James Archdale - Airservices Australia Assessment - White Rock Wind Farm (Airservices Ref - NSW-WF-011)

From: James Archdale
To: james.archdale@planning.nsw.gov.au
Date: 4/07/2011 3:35 PM
Subject: Airservices Australia Assessment - White Rock Wind Farm (Airservices Ref - NSW-WF-011)
CC: Doherty, Joe; Quigley, Kent

Subject: Airservices Assessment - Proposed White Rock Windfarm - West of Glen Innes

Airservices Australia has completed an assessment of a proposed White Rock Wind farm - West of Glen Innes. At a maximum blade tip height of 1556.0m (5105ft) AHD, the proposed Wind Farm will affect the 10 MSA (minimum safe altitude), the Sector A DME/GPS Arrival and the Sector B DME/GPS Arrival. No other sector or circling altitude, nor any approach or departure at Glen Innes airport is affected.

Figure 10-1 Aerodromes within vicinity of the proposed wind farm

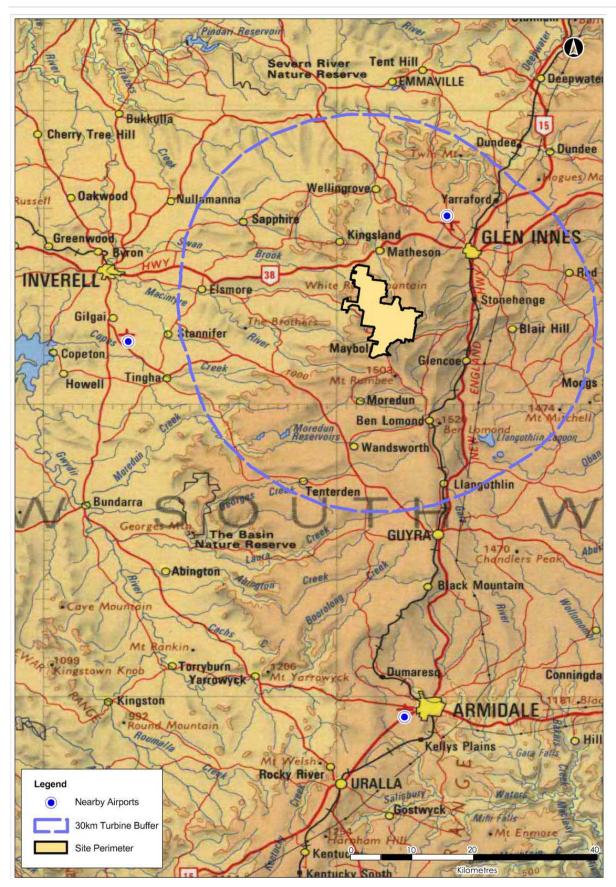
The Airservices Australia assessment indicated that this proposed wind farm will have an affect on the 10 (NM) MSA and two procedural arrivals into Glen Innes Airport. To date, Airservices has received no response to this assessment.

At a maximum blade tip height of 1556.0m (5105ft) AHD, the proposed Wind Farm will affect not affect any sector or circling altitude, nor any approach or departure at Inverell airport.
